**Sent:** 25 May 2010 11:38  
**To:** Planning  
**Subject:** Comments Added: 93 The Ridgeway, Cuffley

Application ID: S6/2010/747/FP Mr P Jefcoate Application Owner: Welwyn & Hatfield  
Borough Council (Development Control Officer)  
Applicant: Hertford Planning Service  
Location: 93 The Ridgeway, Cuffley  
Deadline Date: 28/05/2010 00:00:00  
Description: FORMATION OF JULIET BALCONY AND ERECTION OF SINGLE STOREY SIDE AND REAR  
AND PART FIRST FLOOR SIDE EXTENSION WITH DORMERS Comment Added:

Drawing Proposed Scheme
Plans and Elevations
with Juliet balcony

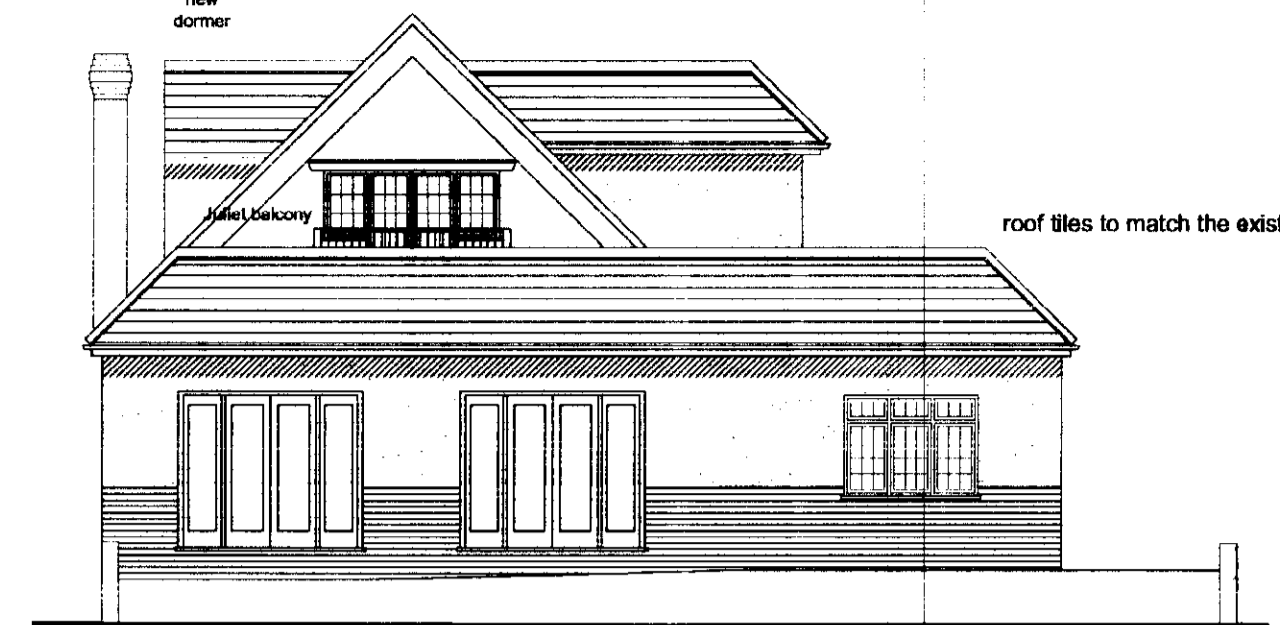
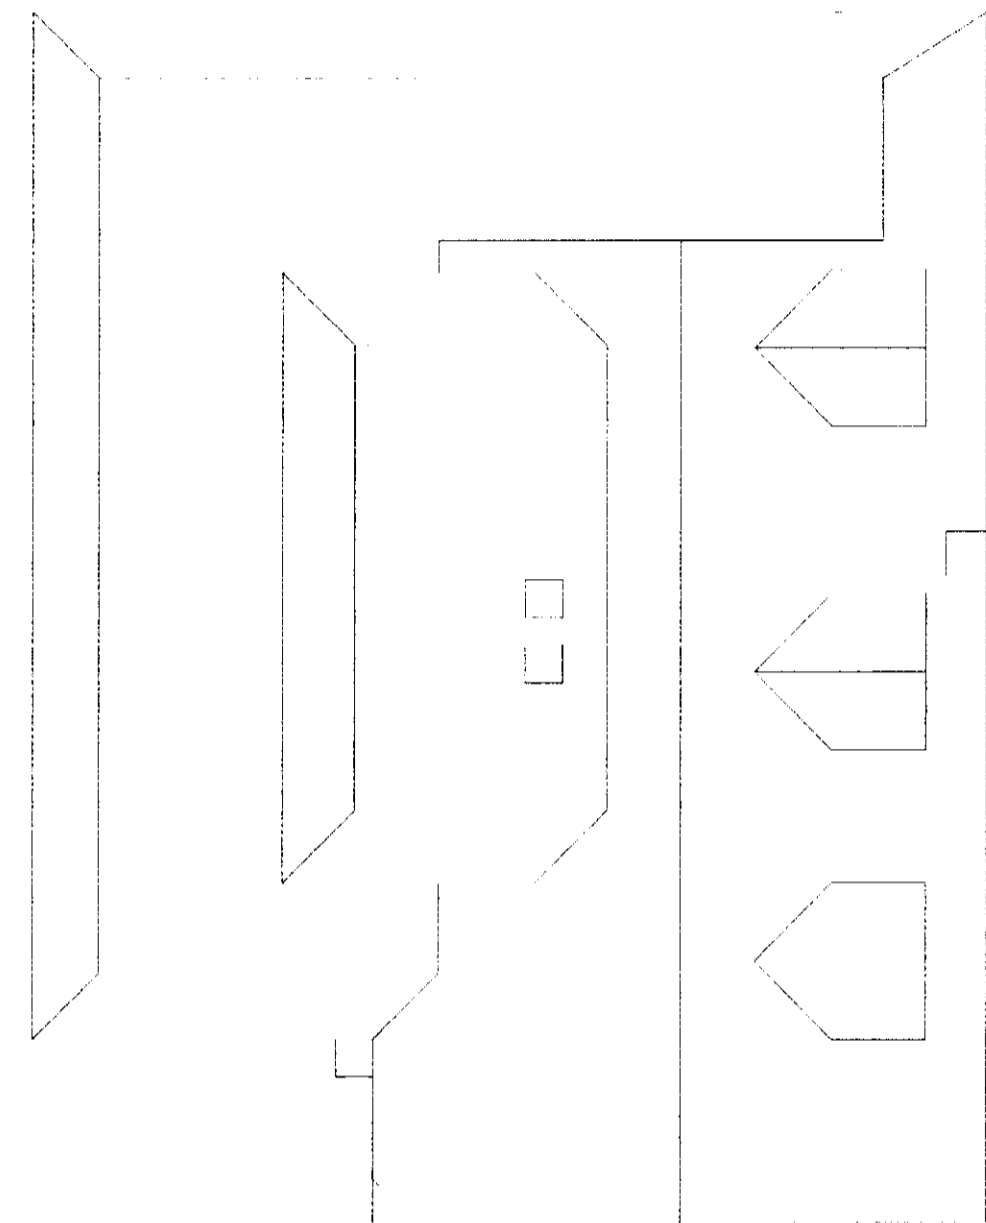
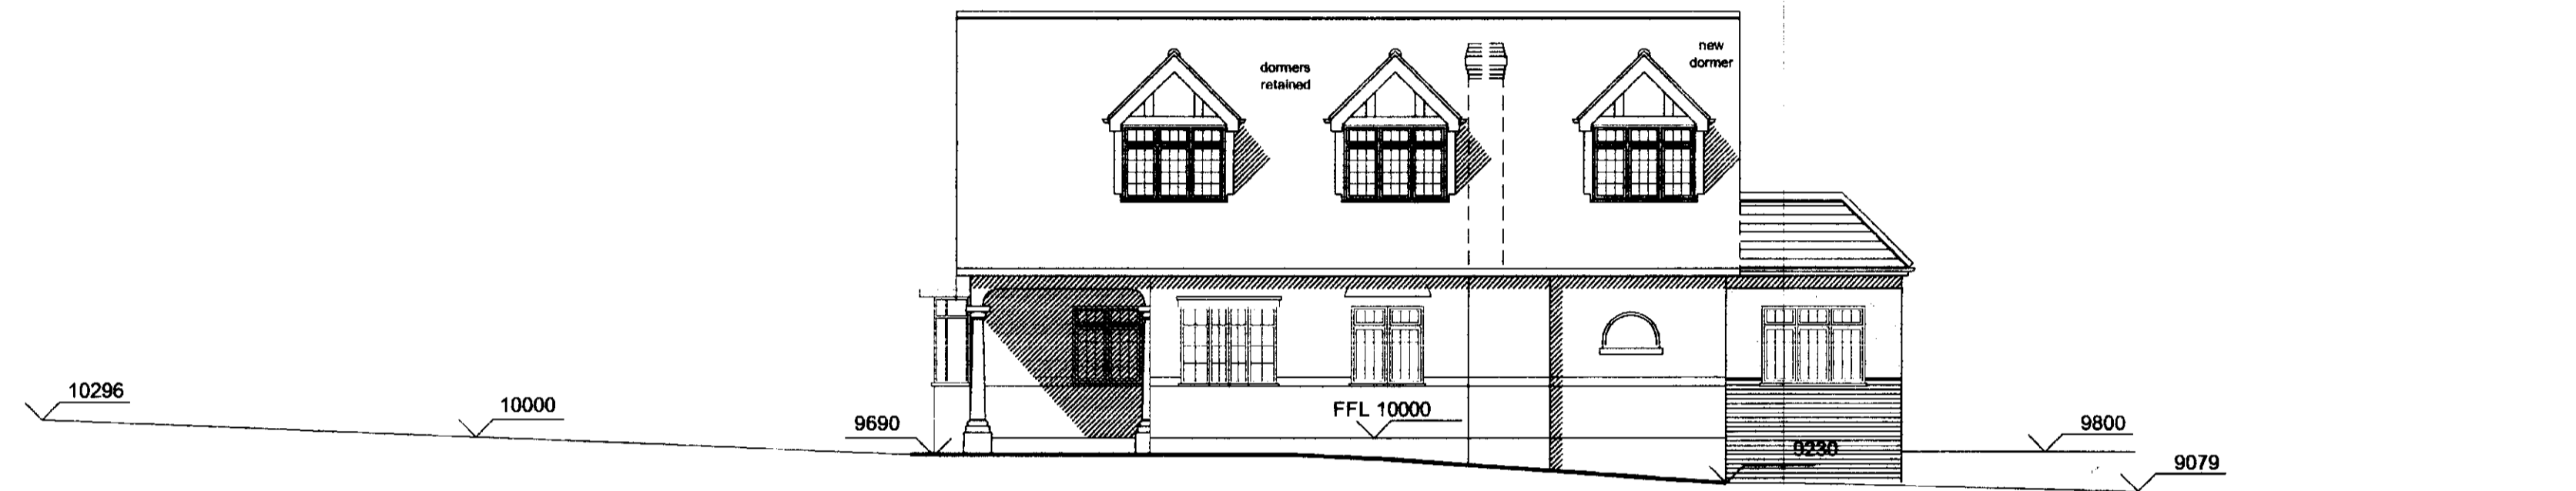
Comment: The PC have been unable to see existing elevations to check how different the extension will be and have no drawing of the "Juliet balcony" at all. However this seems to be in line with other on The Ridgeway.
